File Ref. No: FRN17/2204-9 BFS22/4837 8000023836  
TRIM Doc. No: D22/83150  
Contact: Station Officer Luke Loseby

20 September 2022

**Re: Advice on Modification Report – OAKDALE WEST ESTATE STAGE 3 DEVELOPMENT- 19 EMPORIUM AVENUE, KEMPS CREEK (SSD-9794683-MOD-1)**

Figure 3: Proposed modified layout (Source: SBA)

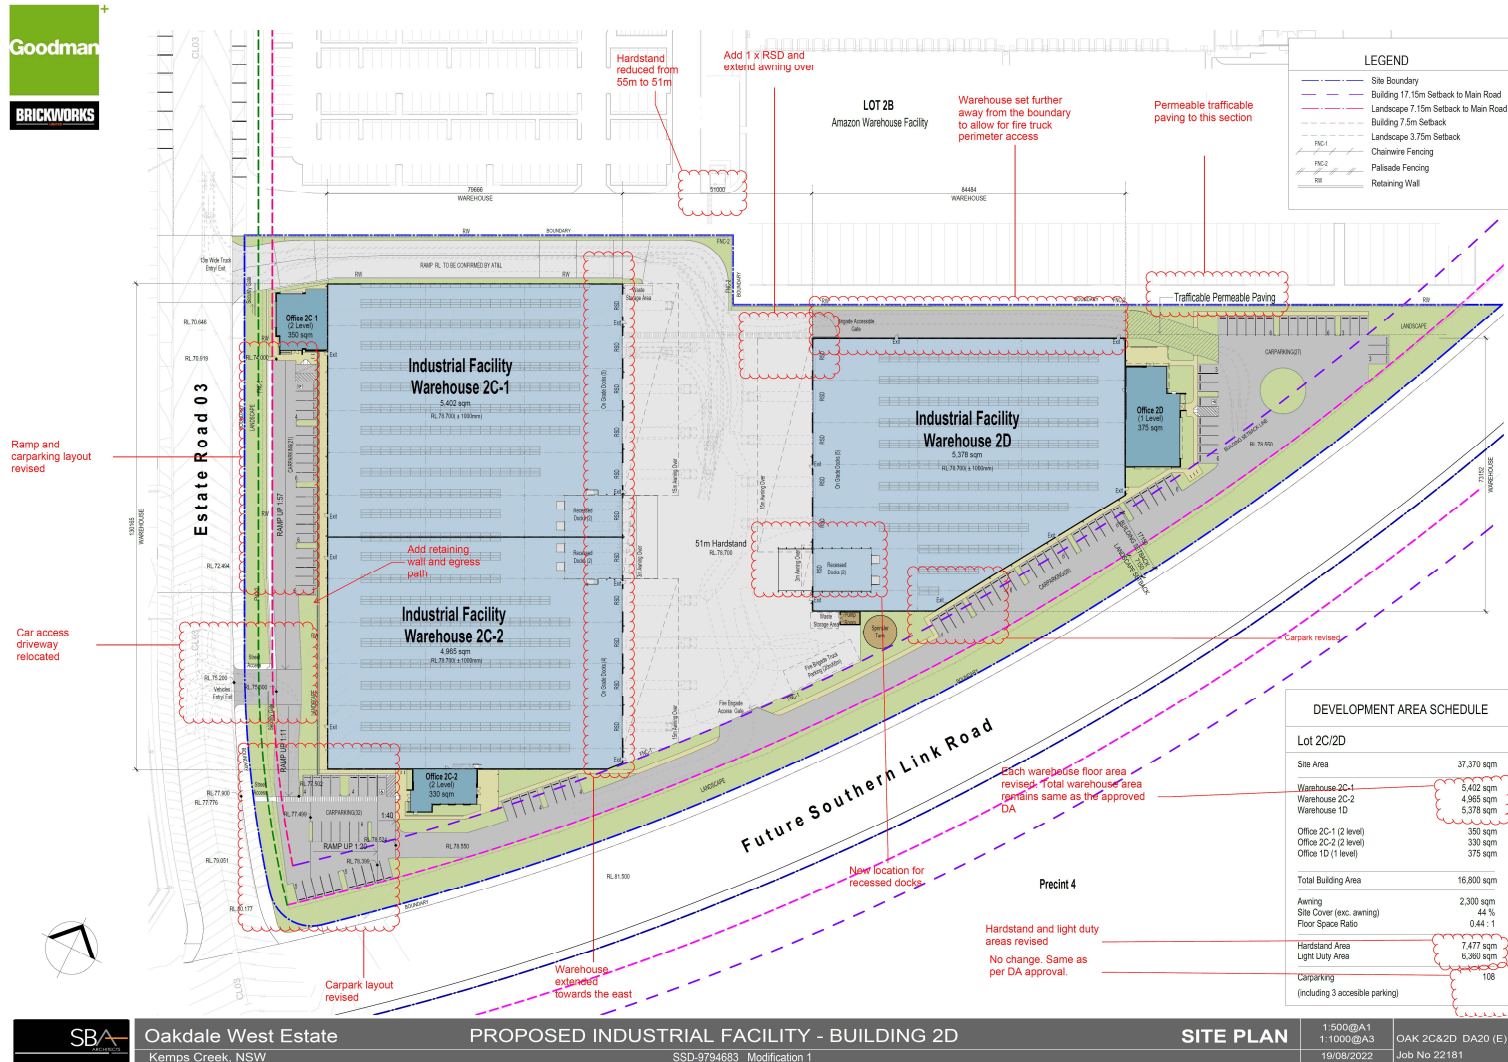
FRNSW note the addition of the new fire access pavement along the northern perimeter of Building 2D and associated minor changes to the layout of the warehouse buildings, FRNSW make the further recommendation:

3. That safe, efficient, and effective access is provided in accordance with FRNSW fire safety guideline – Access for fire brigade vehicles and firefighters.<sup>3</sup>
